Sussex Police
Serving Sussex

Your Ref: LU/116/13

Re: Hollyacre Toddington Lane, Littlehampton, West Sussex.

Thank you for your letter of 30th May 2013, advising me of a proposed development at the above location, for which you seek advice from a crime prevention viewpoint.

Drawing Title  
**Plots 40-41  
Plans and Elevations**

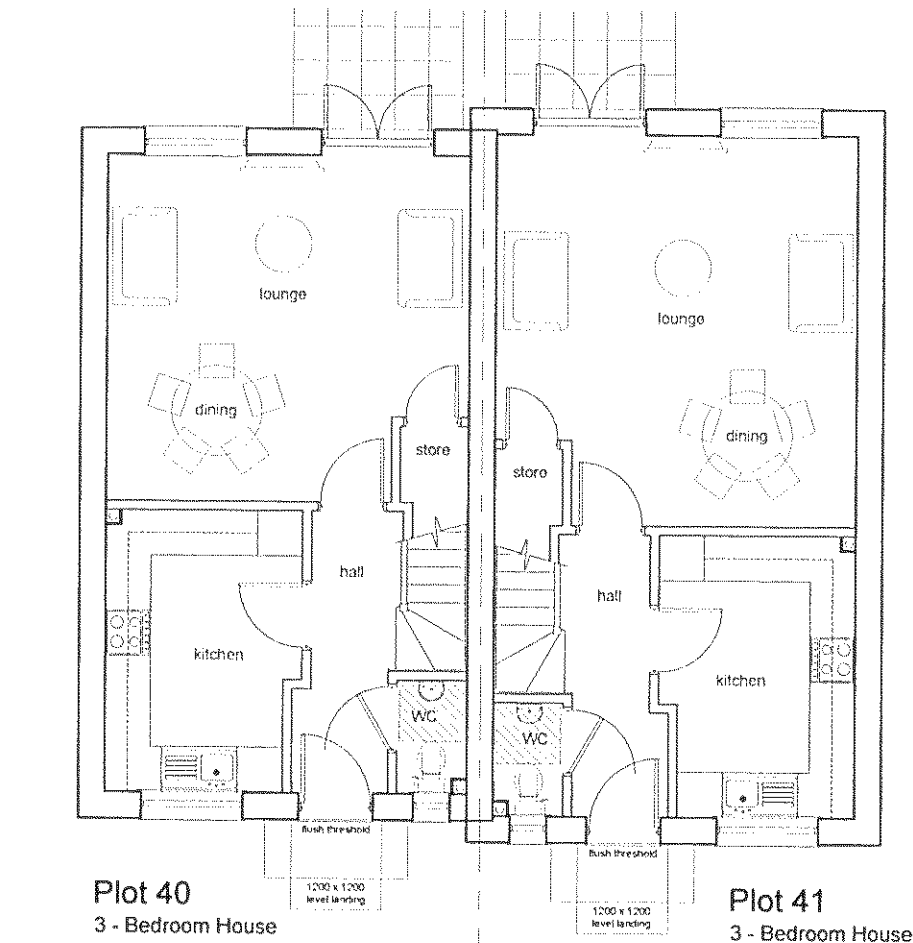
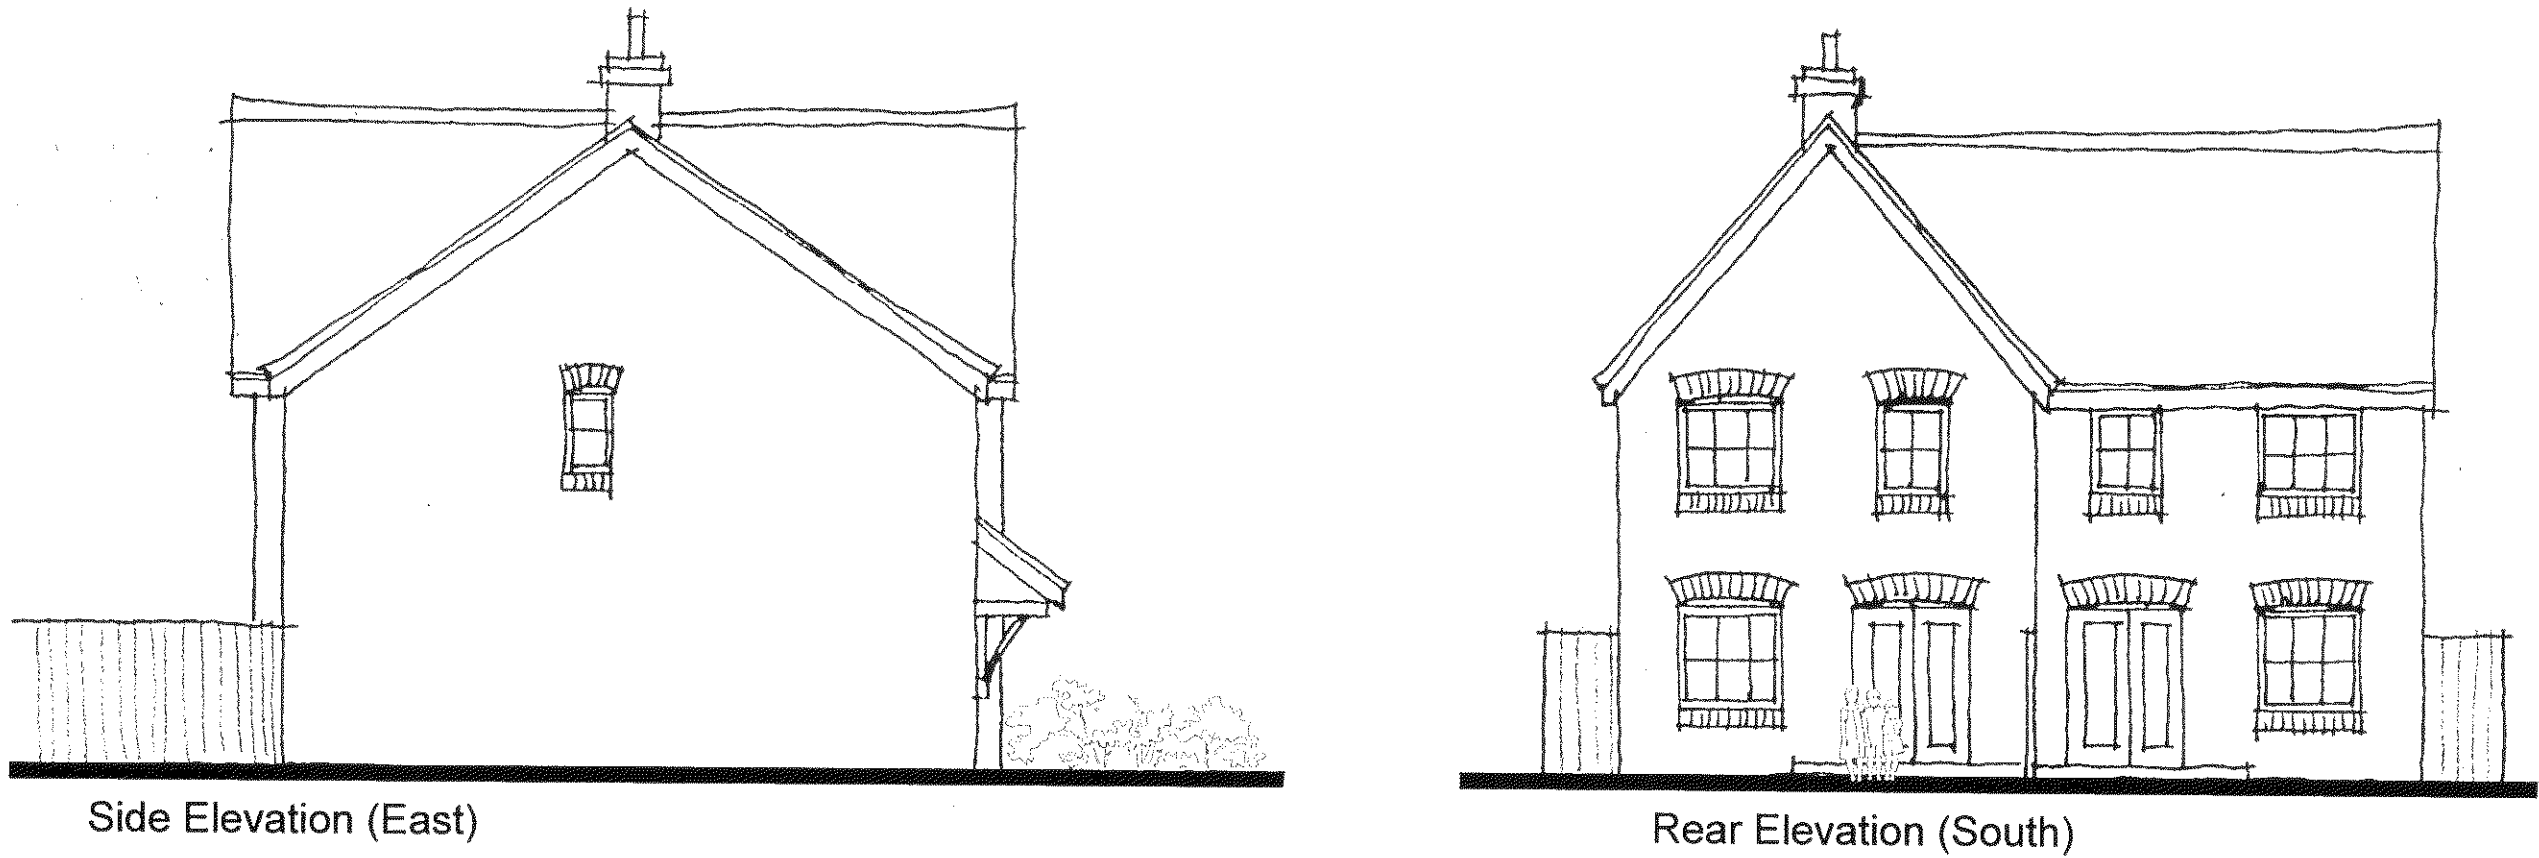
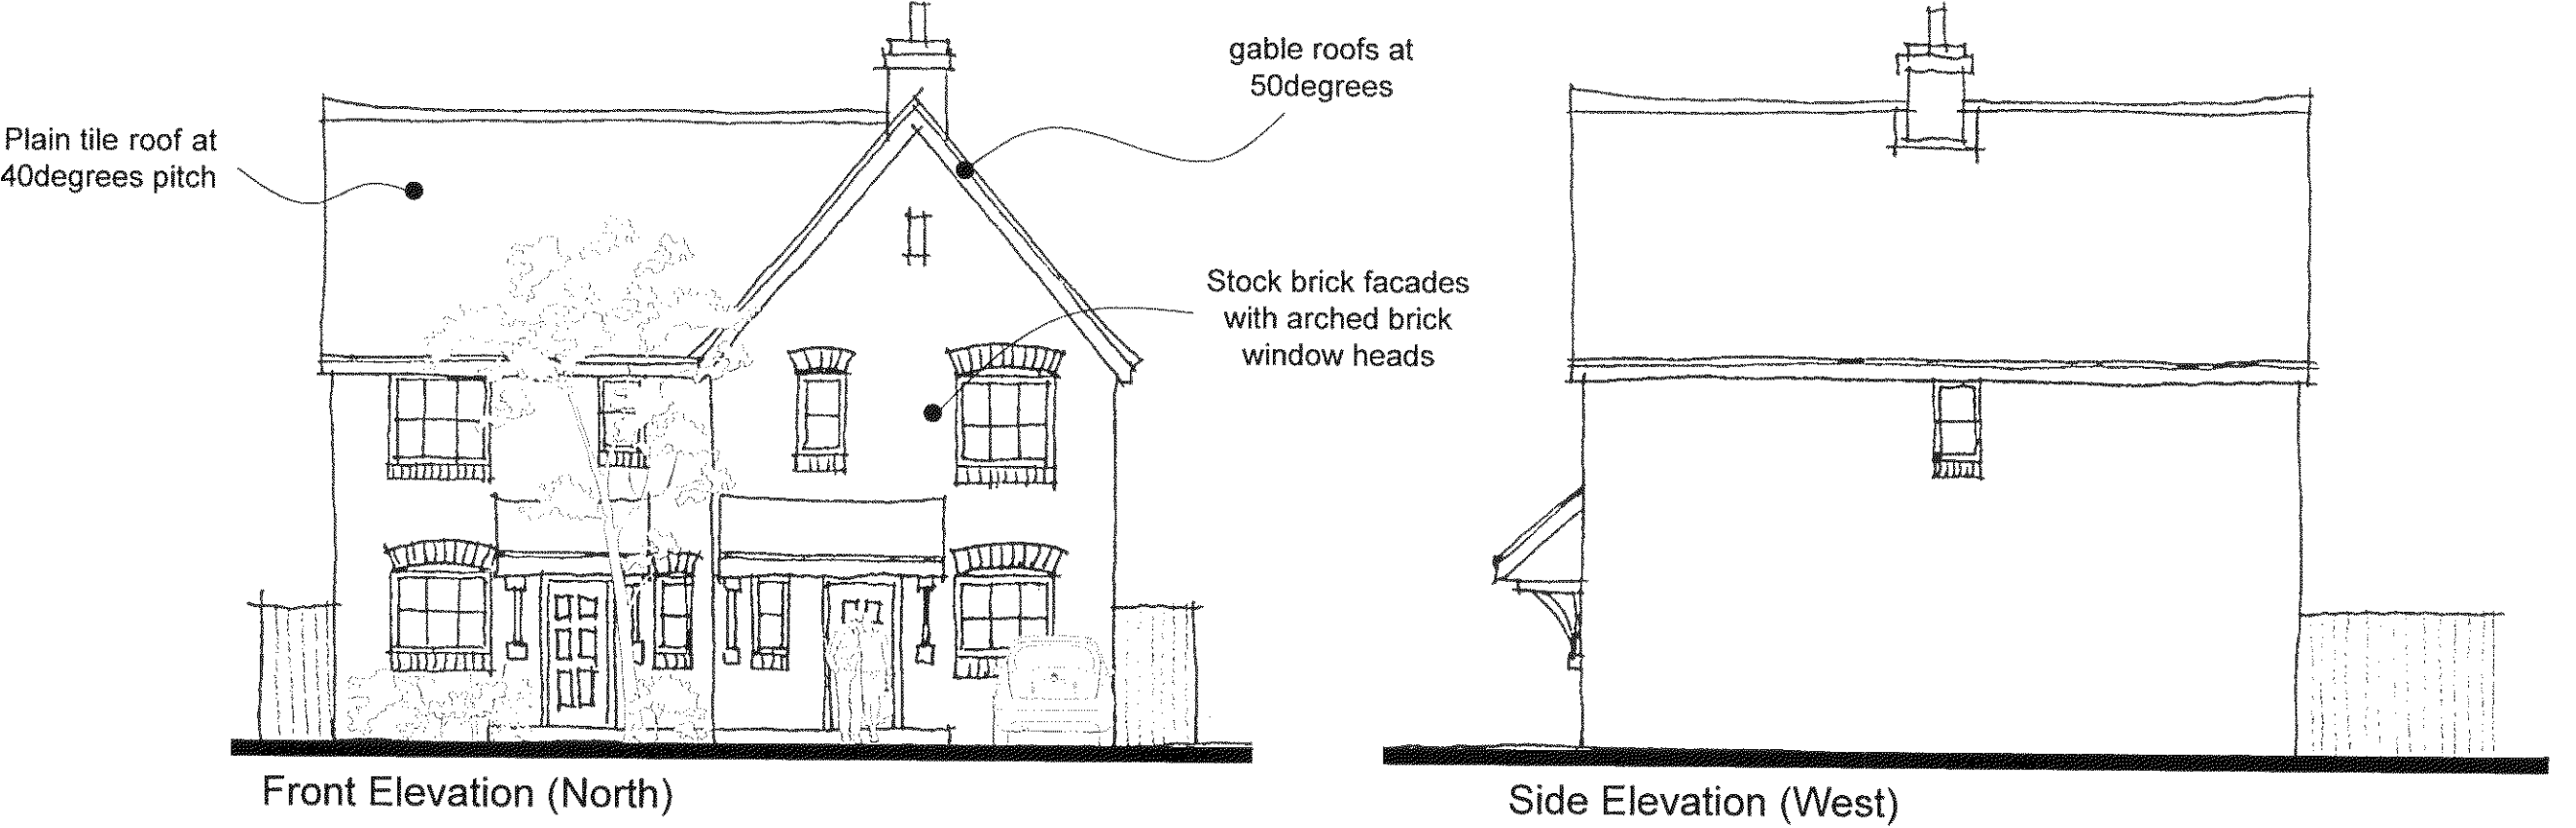
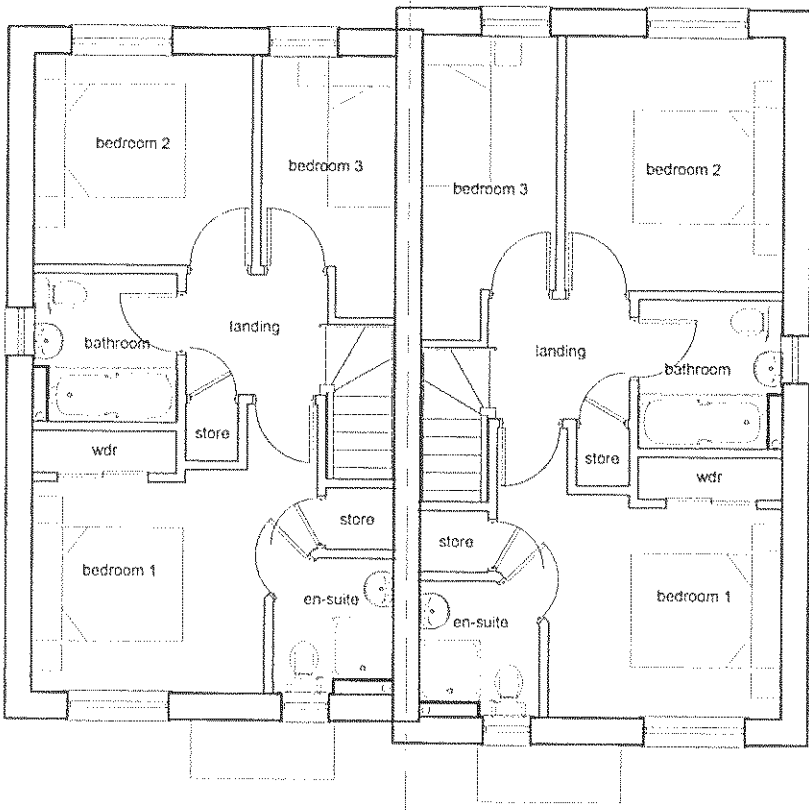
I have concerns over the parking requirements to the rear of plots 32 - 43, and 57 & 58. The parking slots are vulnerable as they are unobserved from the surrounding dwellings. Both are exposed to proposed external pedestrian links leading directly to the parking courts.
